Fort Street Public School / Architectural Design Statement  
Section 4.55 Modification 2- Minor Amendments

Department of Education [SSDA 10340-Mod 2] — REV 06 —11/11/2022

Upper Fort Street, Observatory Hill, Sydney

project code	sheet no.	revision
FSS	DA-2002	SSDA03

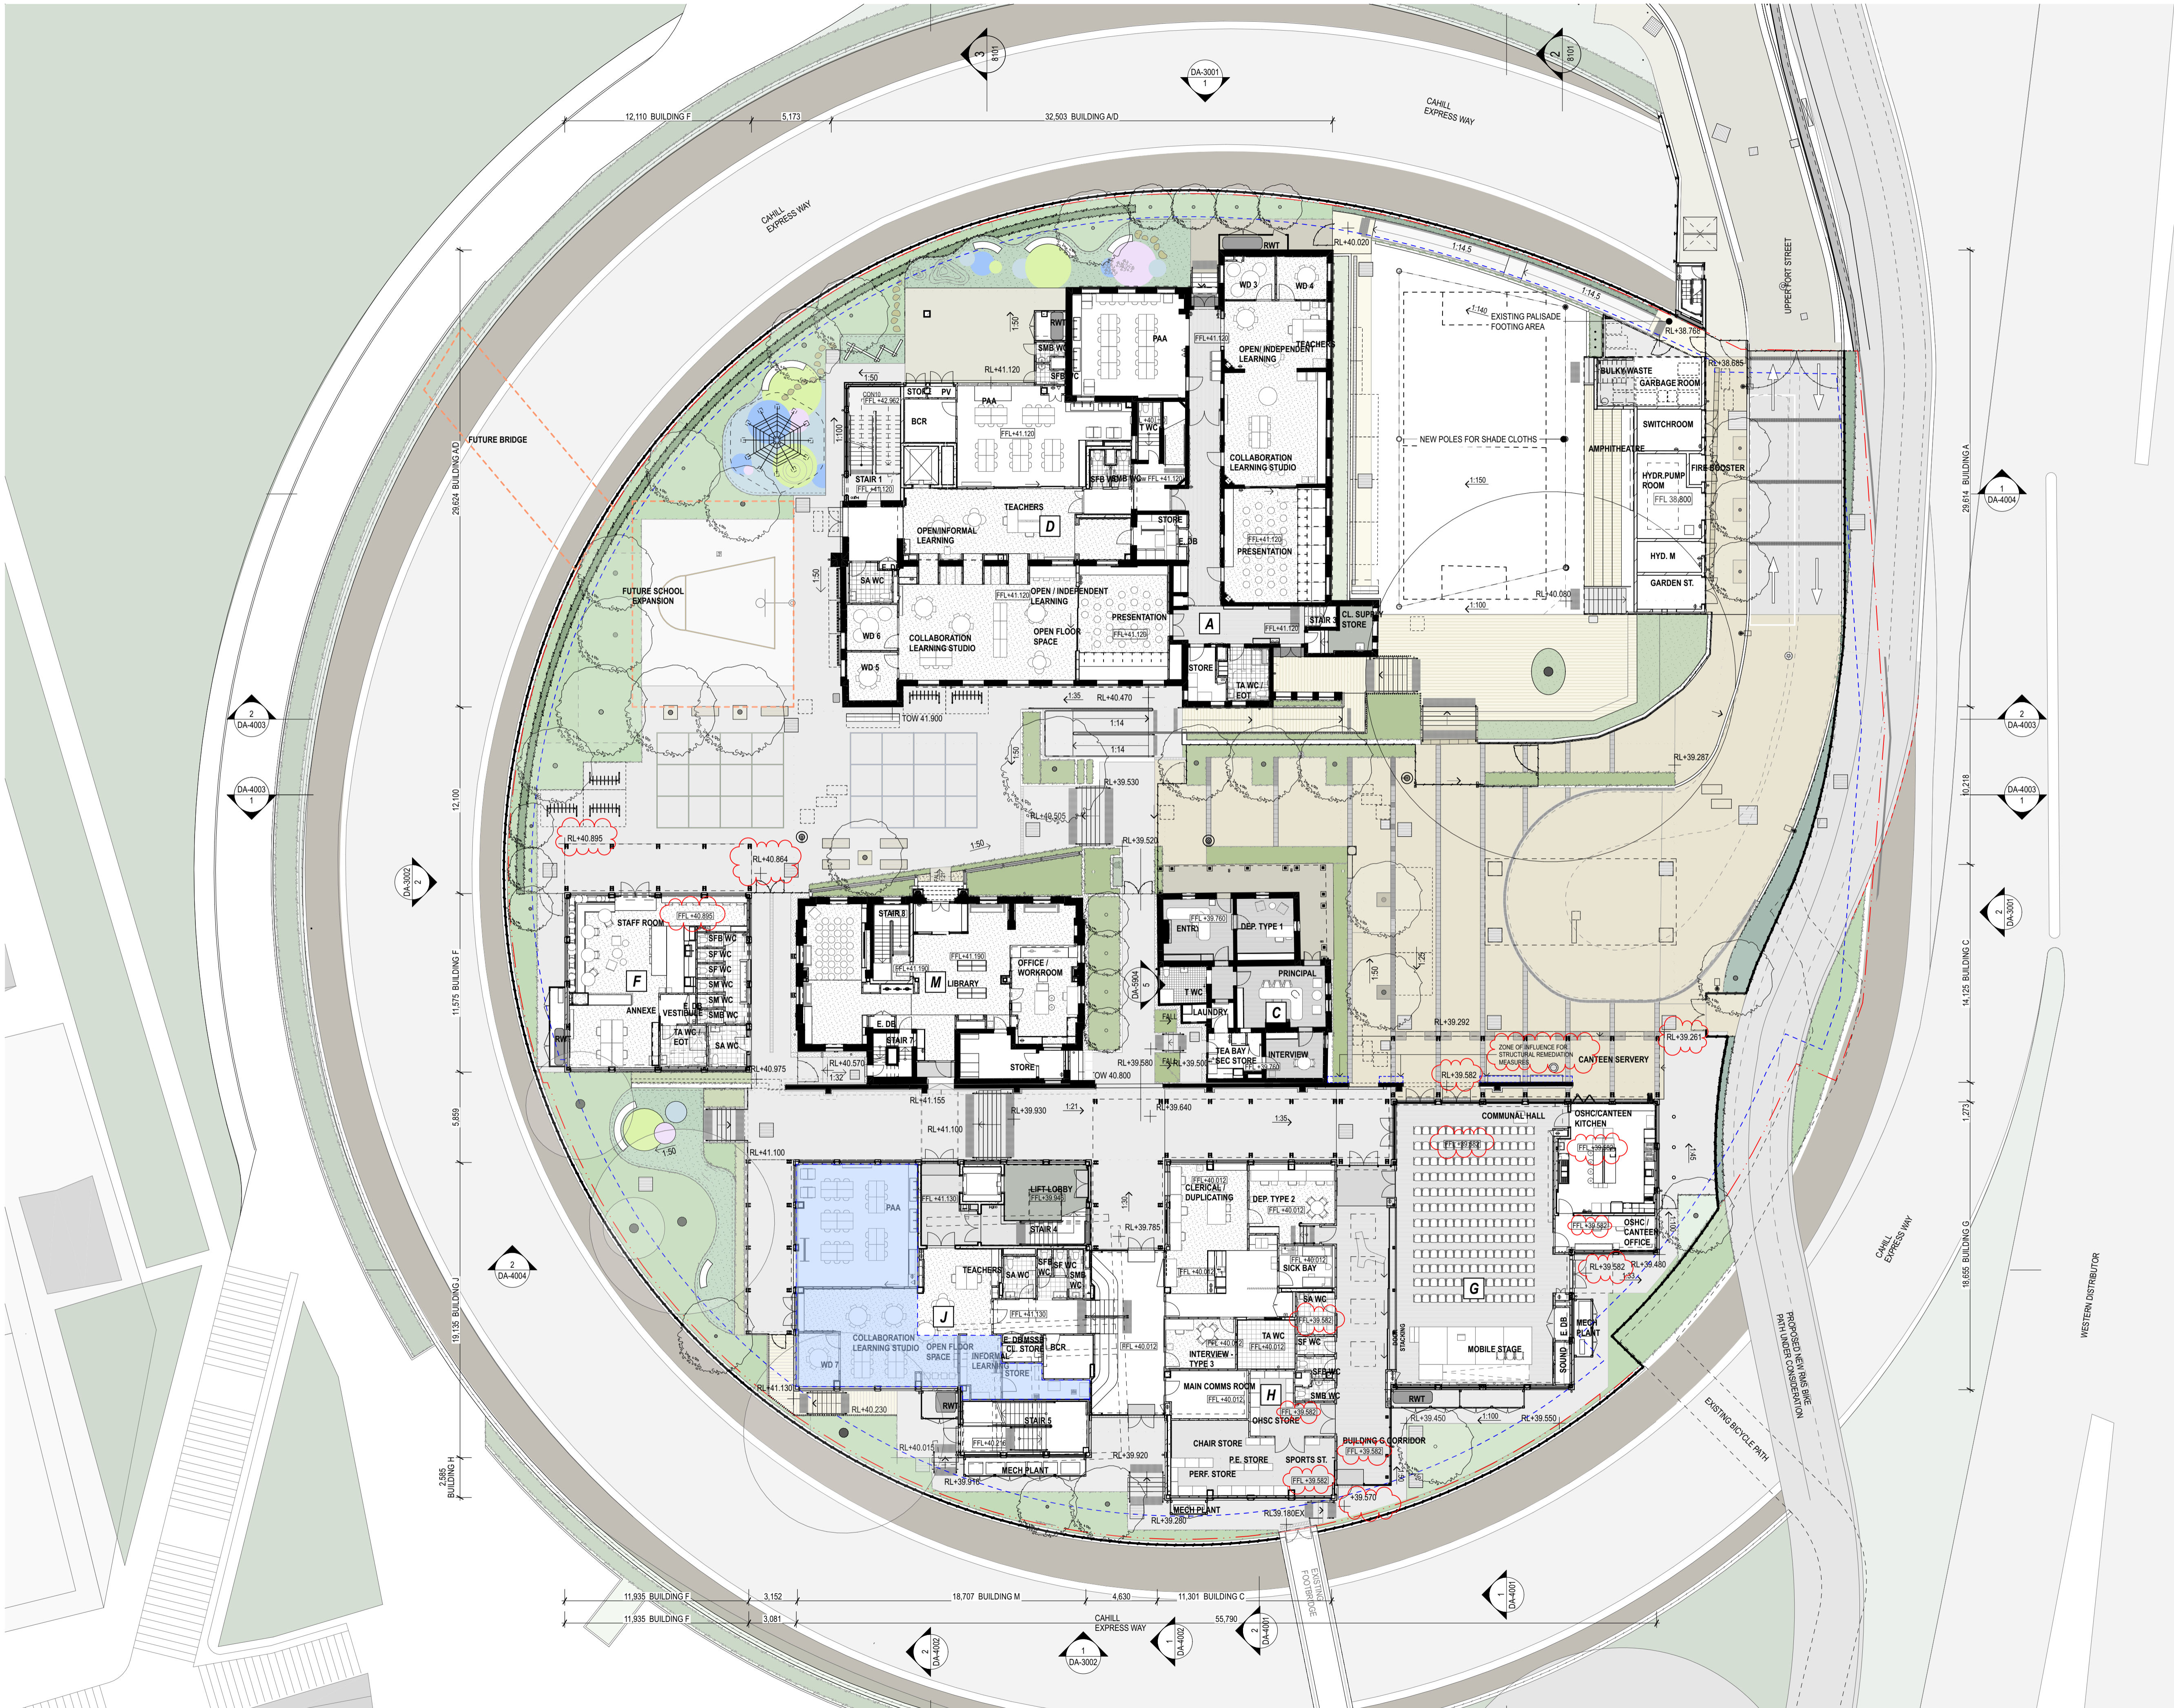
- Building G** - Hall and Canteen Building (eastern campus building)
  - from **FFL 39.754** to **FFL 39.582**, 172mm decrease (lowered)
- Building H+J** - Administration and Teaching Building (southern campus buildings)
  - Level 1 amended from **FFL 45.172** to **FFL 45.086**, 86mm decrease (lowered)

1 ELEVATION NORTH  
1:200

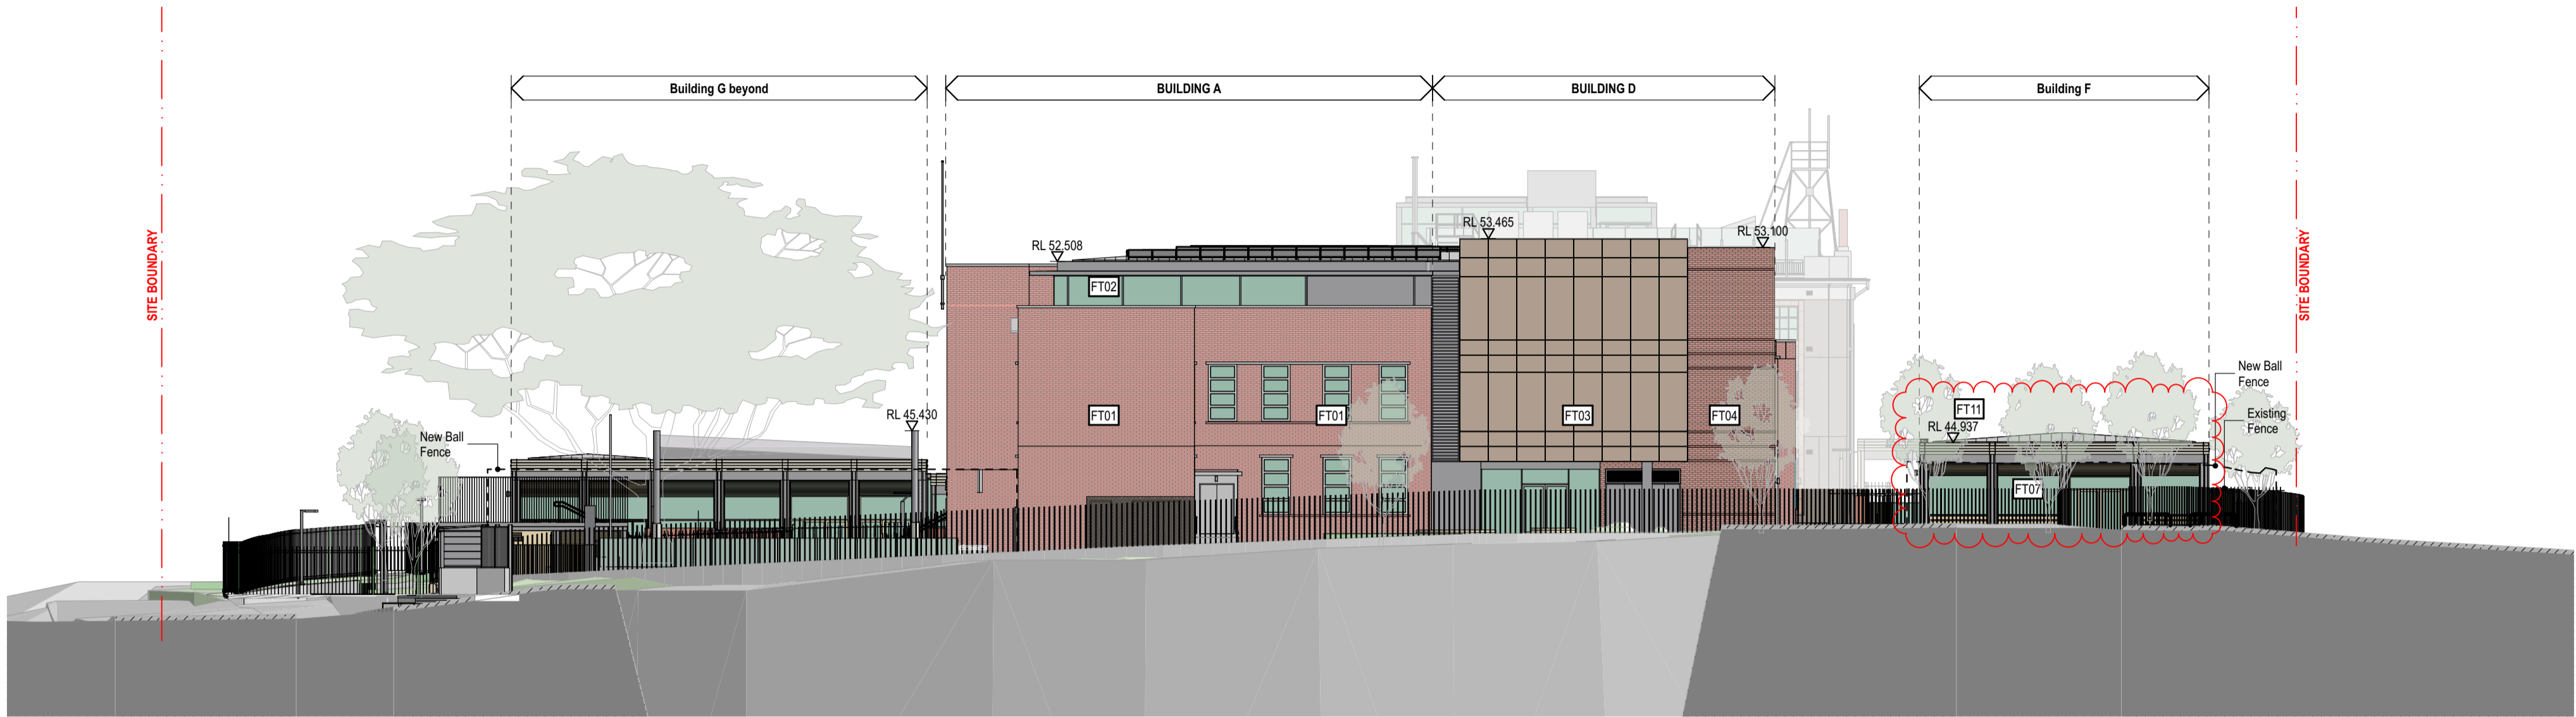
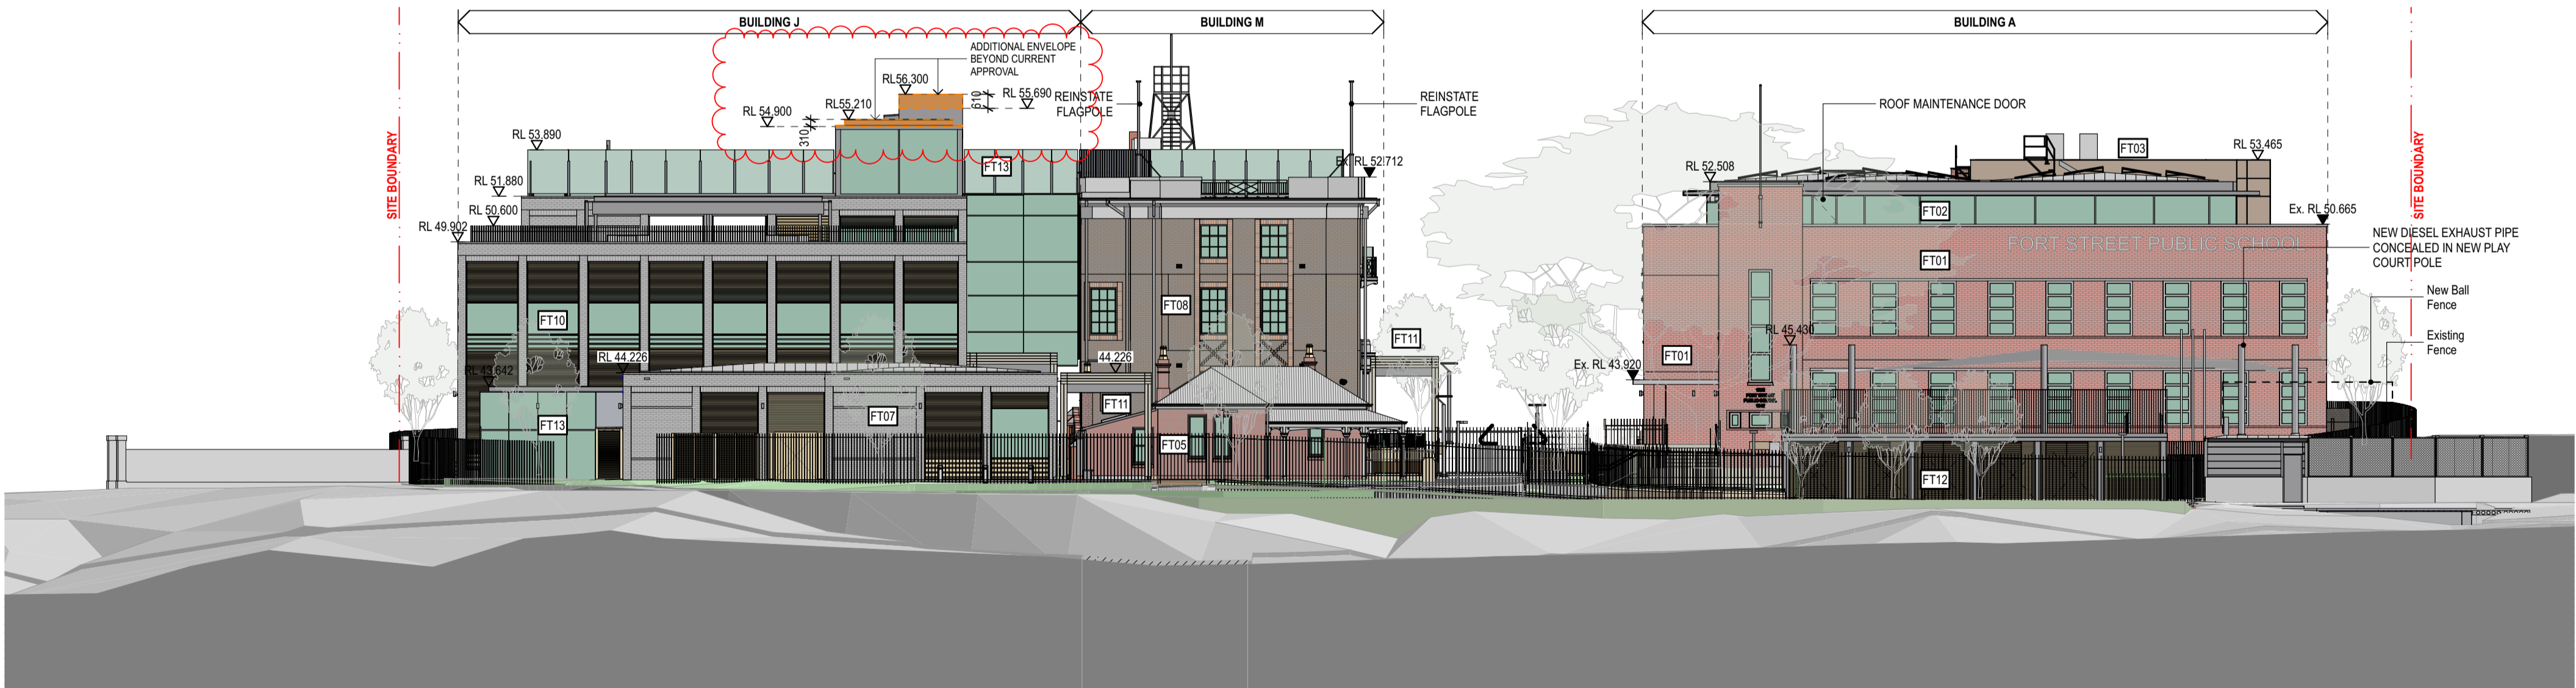
Stair 4 lobby roof	<div>— The proposed increase to the stair and lobby roof is considered to be of greater impact than the raising of the lift shaft, due to its bulk and scale. The Panel notes the constraints of structure and services but none-the-less recommends that further detailed design is undertaken to minimise the height increase.</div>	Drawings were reviewed and considerations for lowering the roof were confirmed showing that further detailed design would not allow a reduction in height. This is due to the size of the sumps , the minimum falls required for the gutter and roof sheeting, and the required size of the steel structure for the roof. Additionally, the roof facade edge detail has been designed to reduce visual impact from below which has been duplicated across the project to retain design consistency.
Stair 4 lobby roof and lift shaft	<div>— The spatial relationship between the lift shaft and the stair lobby roof is considered a minor concern, and the Panel does not believe that the previous relationship between the lift shaft and surrounding foyer roof needs to be maintained.</div>

Issues Related to Design	Consideration/ Stakeholder Feedback	Section 4.55 Mod 2 Response
Lift Overrun	<div>— I suggest that the lift overrun and shaft room should have a visual appearance of a singular form/massing as a continuation of the lift well/shaft i.e. the form/ massing to express its function.</div>	The shape of the form above the new parapet line has the primary stair volume with the smaller, secondary lift shaft volume above. This is a deliberate measure to minimise the visual bulk of the whole by disconnecting the shaft form and allowing it to extend above and behind the leading parapet edge of the stair form. It should be noted that this composition has had explicit input from DPE NSW. On the condition that the internal ceiling height is retained at 2.4m, the consequence of raising the stair parapet to align with the lift shaft will collectively increase the volume and hence apparent volumetric presentation.

Form/Massing	<div><div>— This form/massing at the roof level should not appear as an unrelated rooftop addition such as a mechanical plant room, pavilion (with kitchen and dining facilities), a meeting room, etc.</div><div>— The aim is not to accentuate its height but to express its singular form following its singular function (lift).</div><div>— I suggest that this can be achieved with consistency of design details, articulation, materials, finishes and colour.</div></div>	These 3 aspects are directly contrary to the prescriptive measures imposed by DPE NSW. Specific design measures have been applied to reduce the articulation and simplify the presentation of this form by not extending brickwork or other facade elements beyond the brick parapets; to do so would compete with the brick datums and eave of the existing MET building. Similarly, replicating the detailing adopted at the stair upper lobby back down through the Building J form in that corner will have the visual result of accentuating the height and proportion, in competition with the MET, and hence undermining in part the hierarchy as the MET as the prominent building on the height.

- lift shaft roof from **RL 55.690** to **RL 56.300**, 610mm increase
- stair lobby roof - **RL 54.900** to **RL 55.210**, 310mm increase
